Our Ref: TR/7874/jj

7 September, 2012

RE: WARNERVALE TOWN CENTRE

1 PROPOSED FLOOR PLAN - CP2
1:400

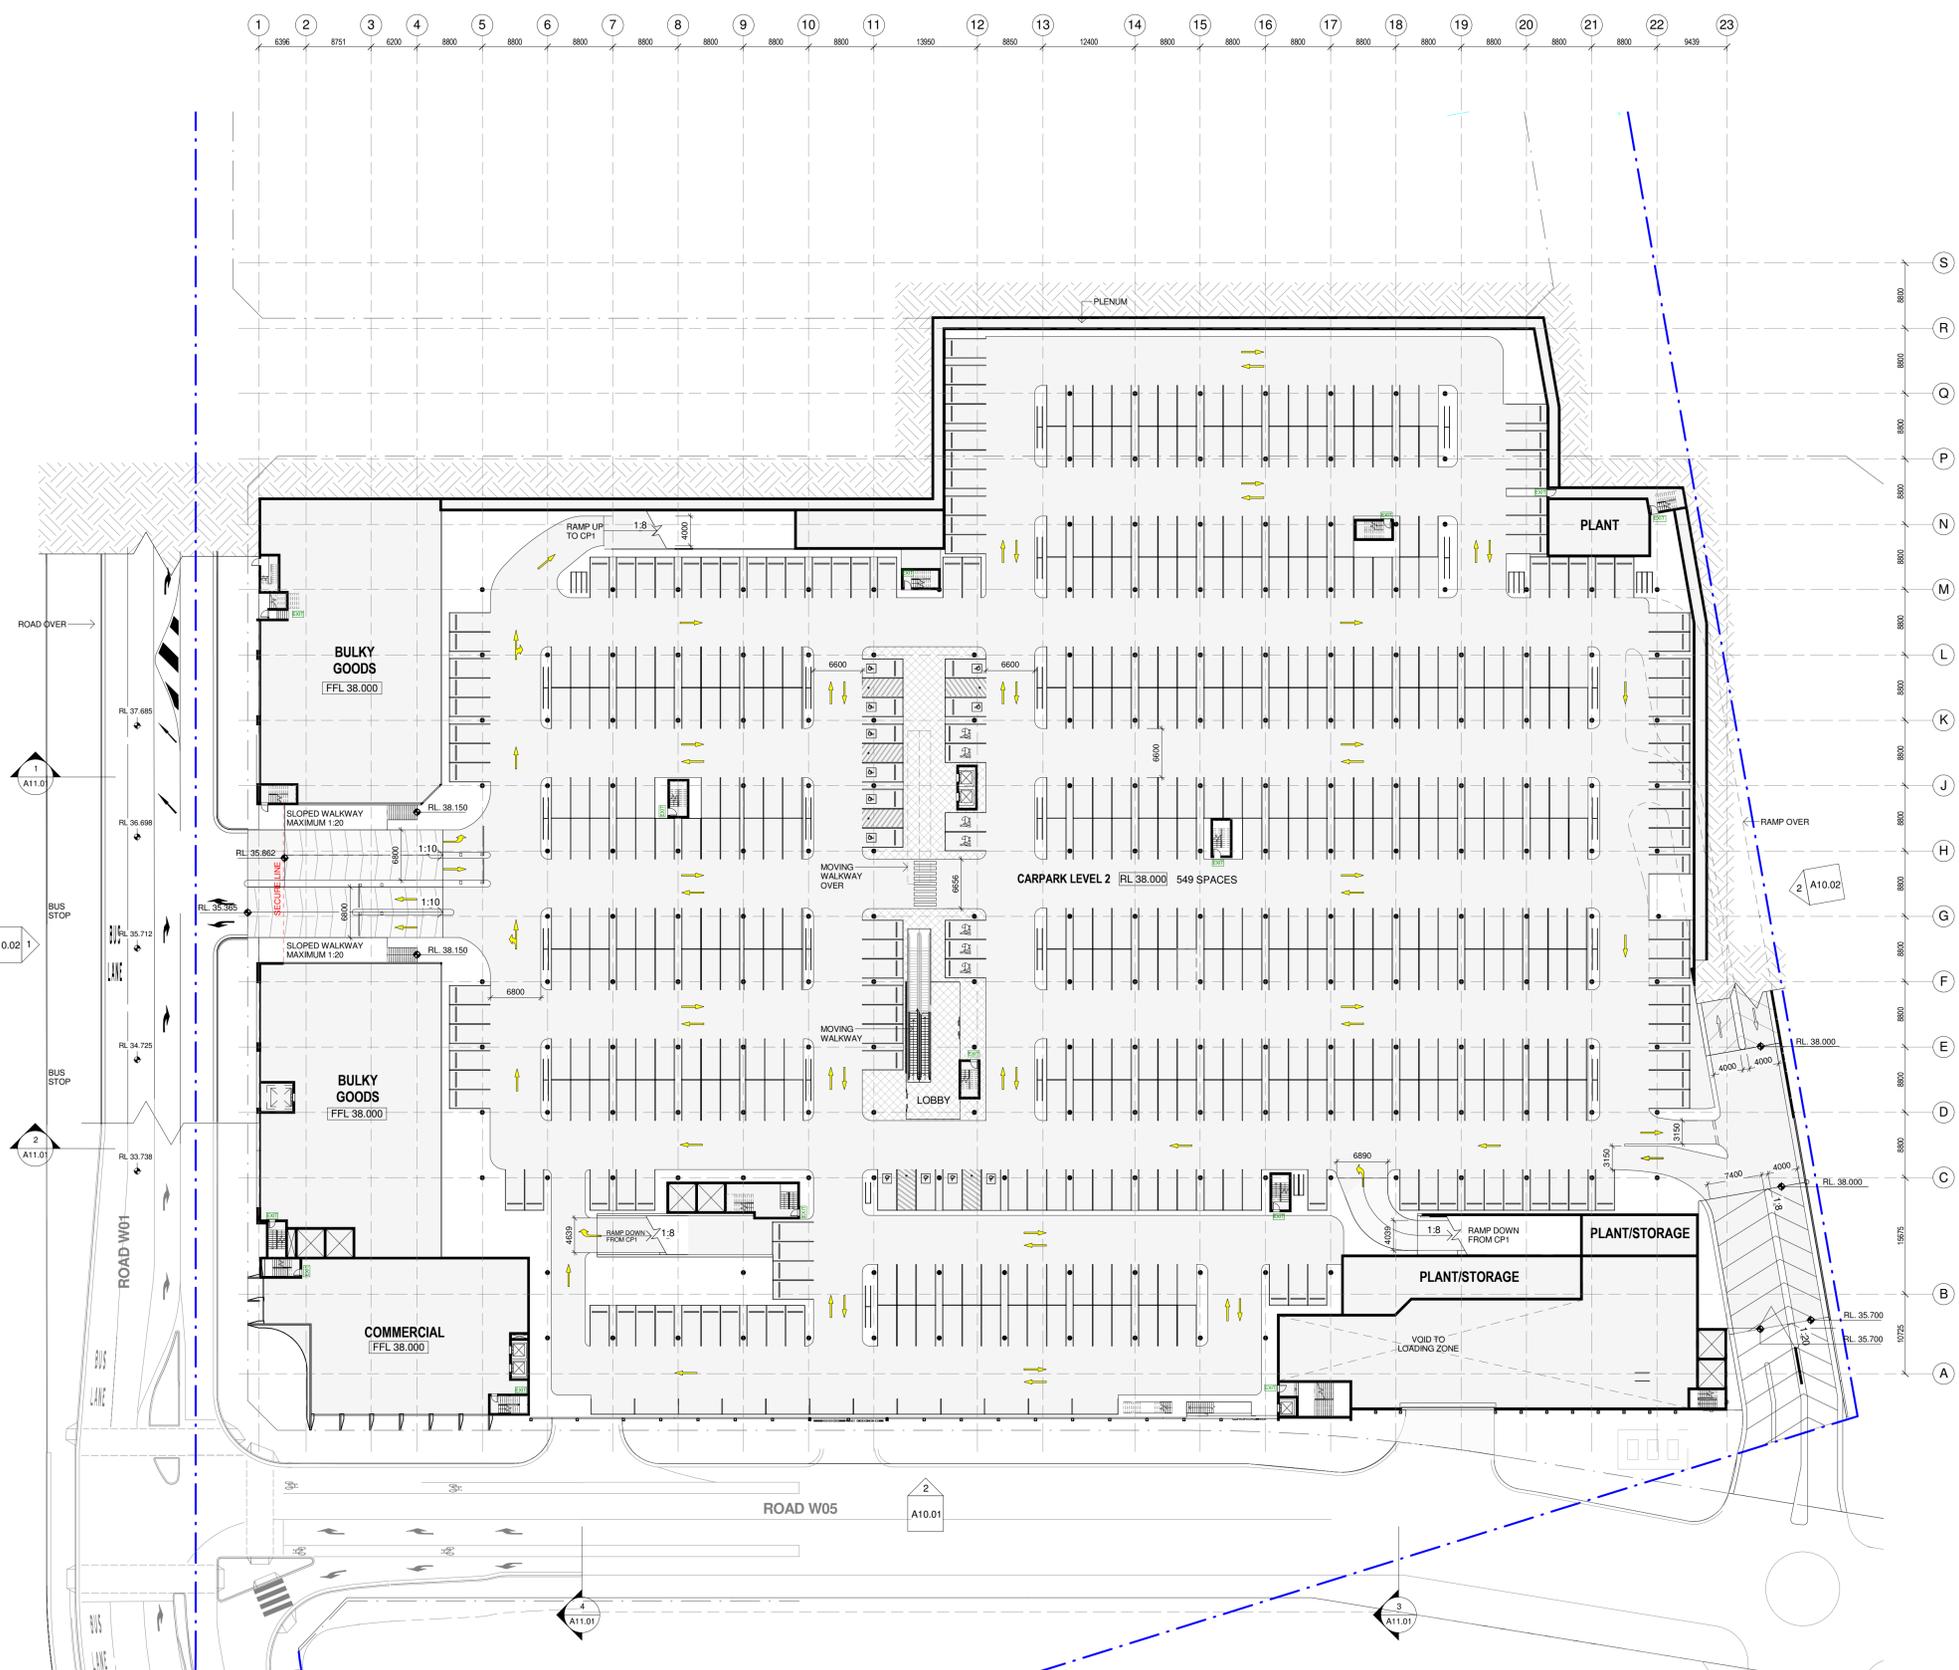
4. Access to level CP2 of the car park from Road W01 is consistent with original planning proposal and is important to provide appropriate access to the shopping centre car park. The shopping centre provides 1,200 parking spaces with three access points (Road W01 via CP2, Road W05 via CP1 and a secondary link through the northern car park to Road W01 via CP1). It is good traffic engineering practice that access for large multi deck car parks should be provided to different levels of the car park and to different streets. This allows

for ease of access and to efficiently distribute traffic. One access point for every 300 to 500 parking spaces is considered appropriate. The proposed provision of three access points, with the two main access points servicing different levels of the car park and to different streets, is in accordance with these principles and is supported.
